**Lead Local Flood Authority
Ground Floor
Northleigh
County Hall
Chichester
West Sussex
PO19 1RH**

Date 08 January 2026

Planning Reference: **P/167/25/RES**
Site Address: **Land South of Summer Lane Pagham**
Planning Description: **Approval of reserved matters following outline consent P/15/24/OUT in relation to the spine road. This application is in CIL Zone 4 (Zero Rated) as other development.**

ELEVATION OF HEADWALL
OUTFALL TO END OF DITCH

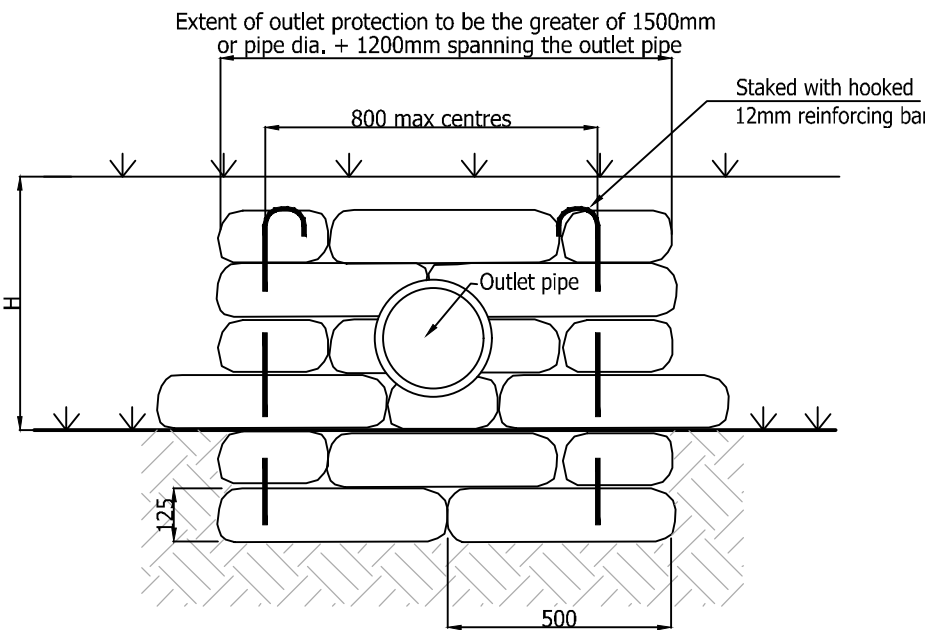
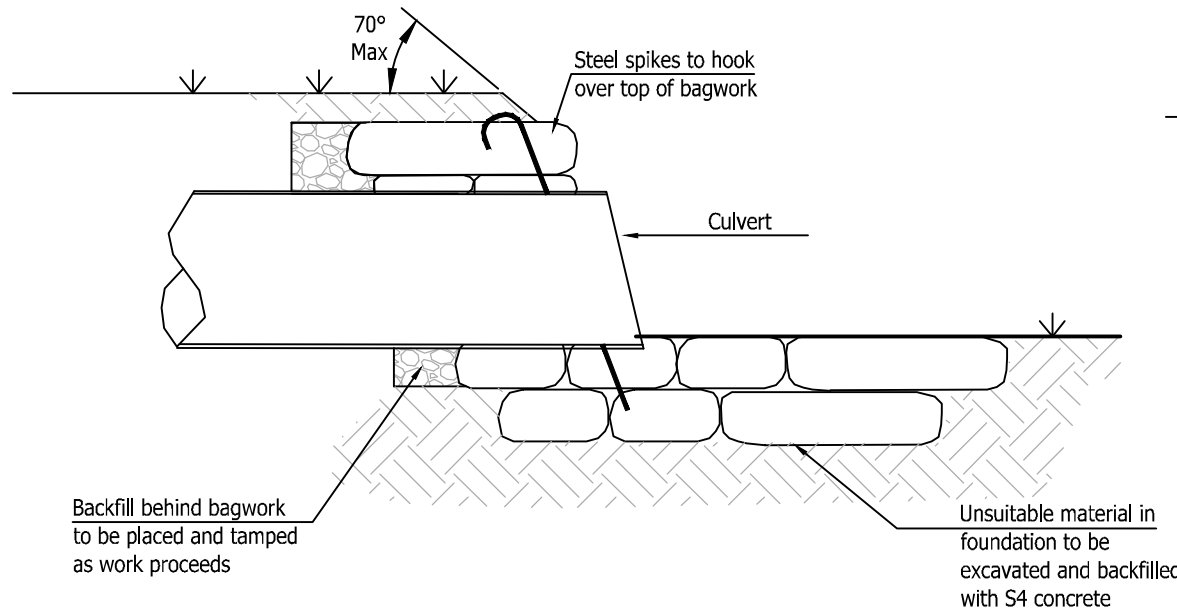
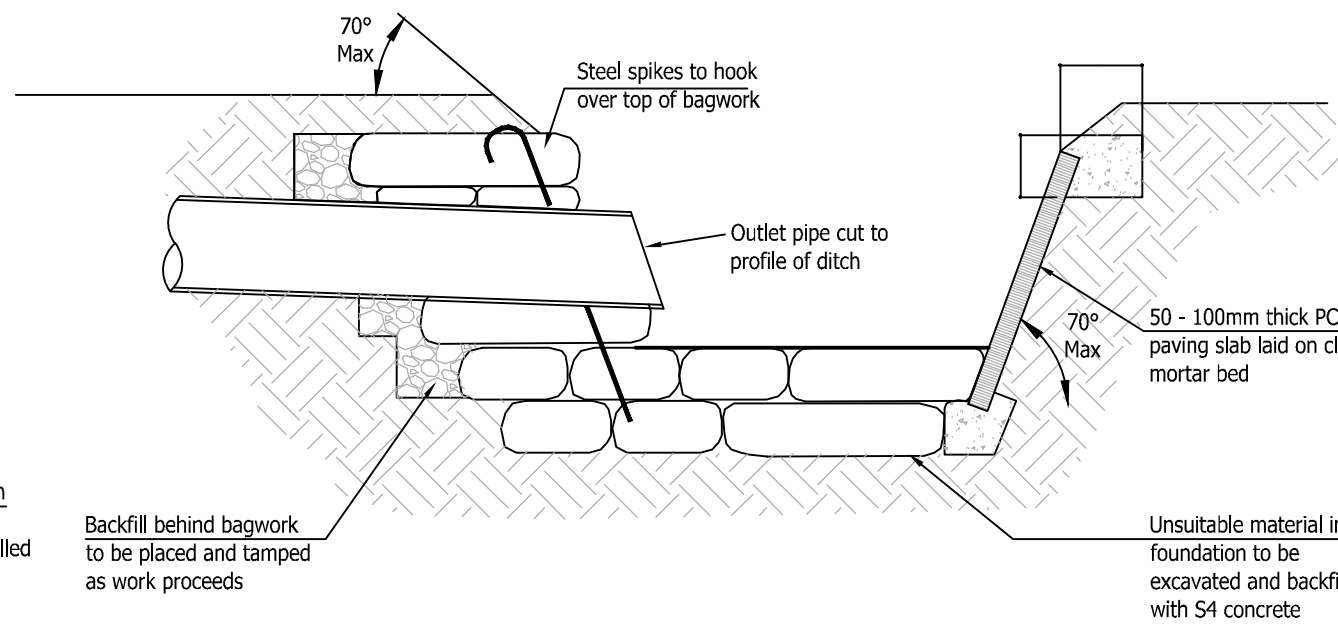
Further details including drawings should be submitted in relation to the proposed crossing above the existing ditch. **Further information is required.**

Flow Control Chamber Typical Detail

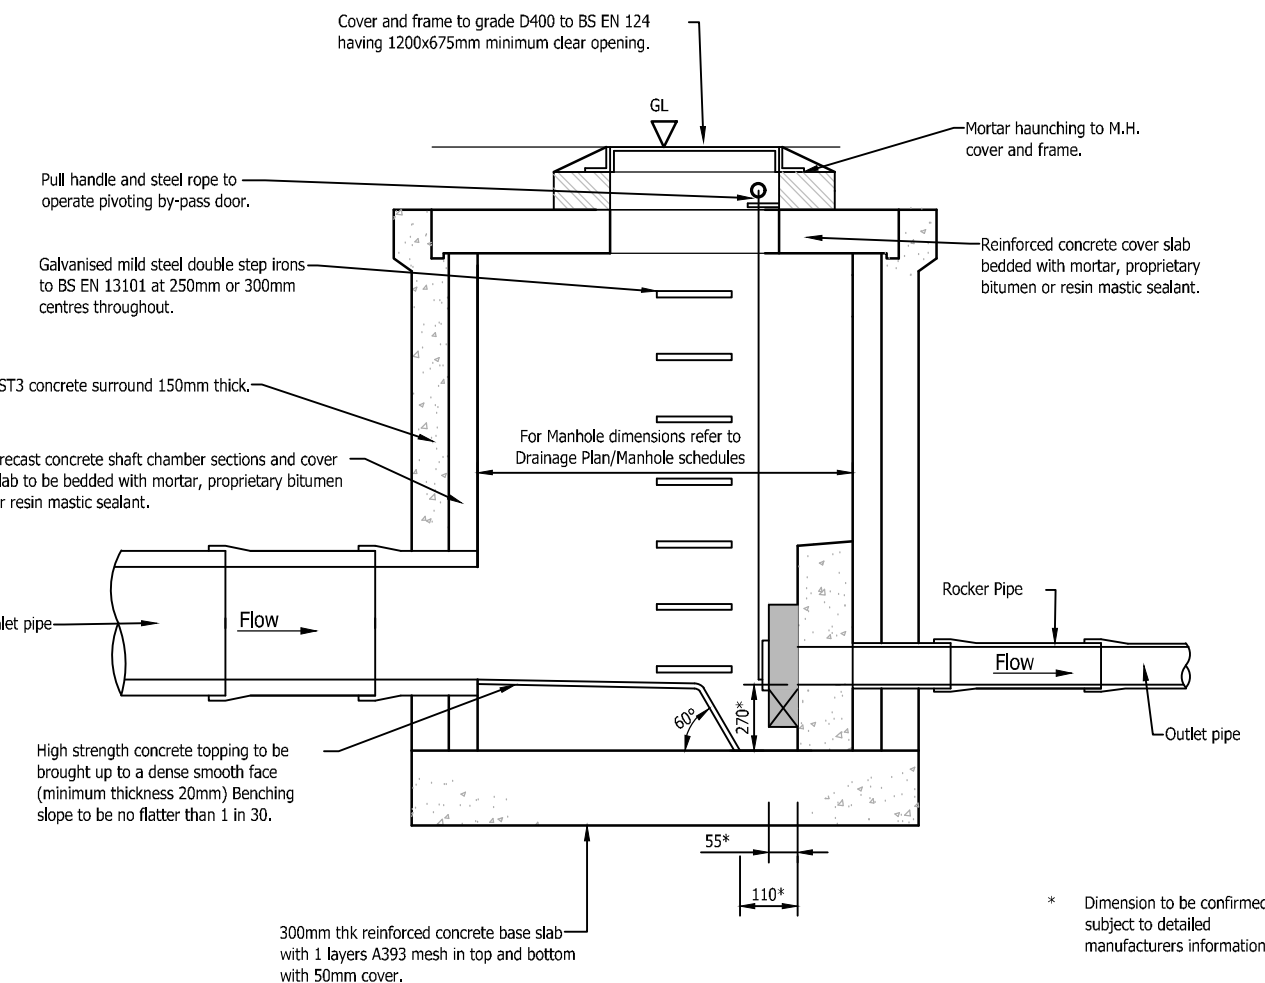
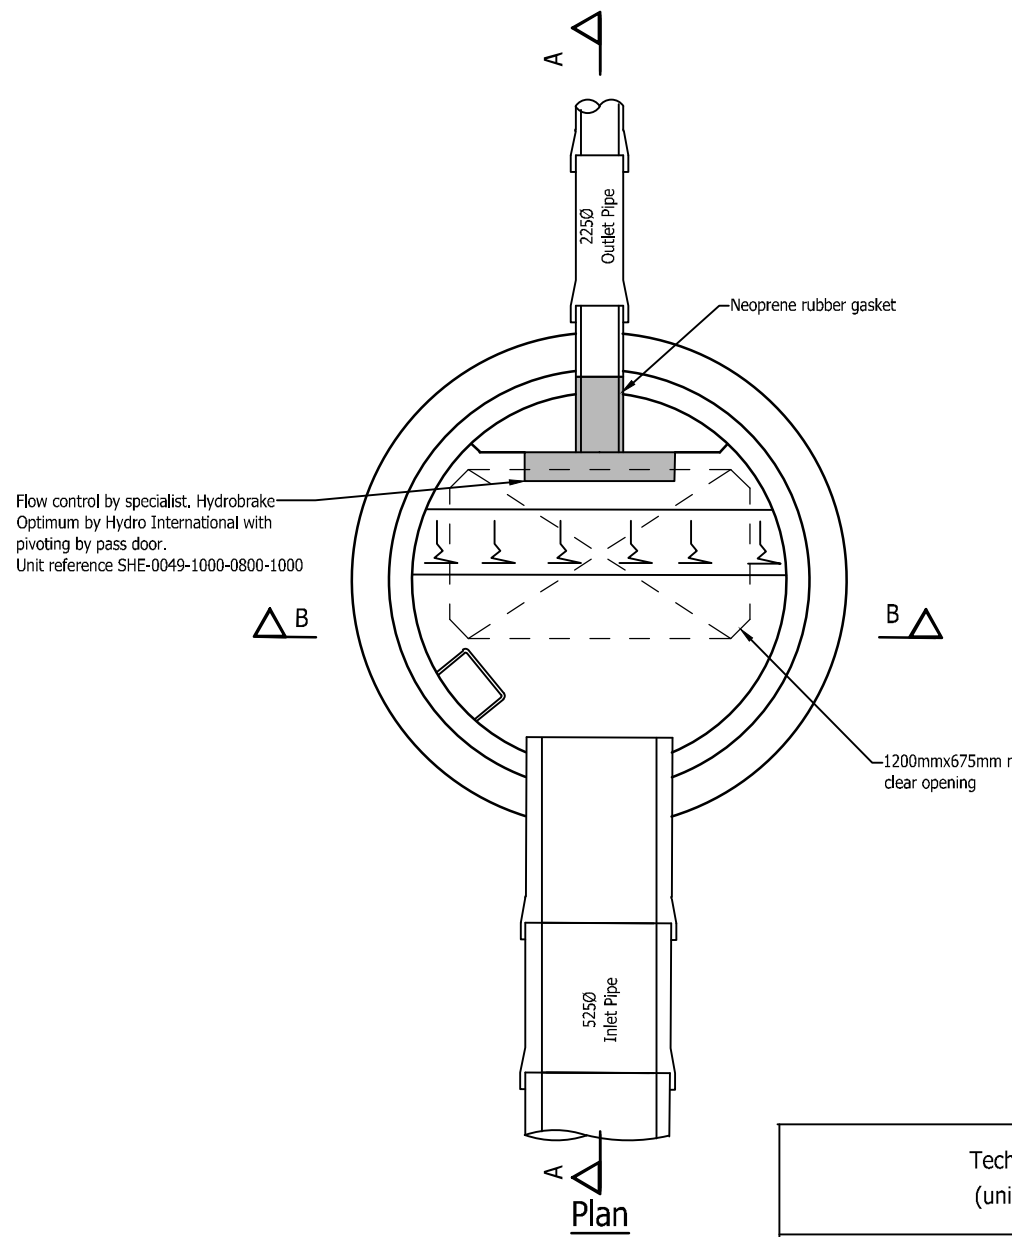
The wording of the Condition requires construction drawings to be provided for the surface water drainage network and associated sustainable components. The drawings that have been submitted are labelled as 'Initial Issue' and most show typical details of the surface water drainage components. A full construction method statement is also required as per the Condition wording. **Further information is required.**
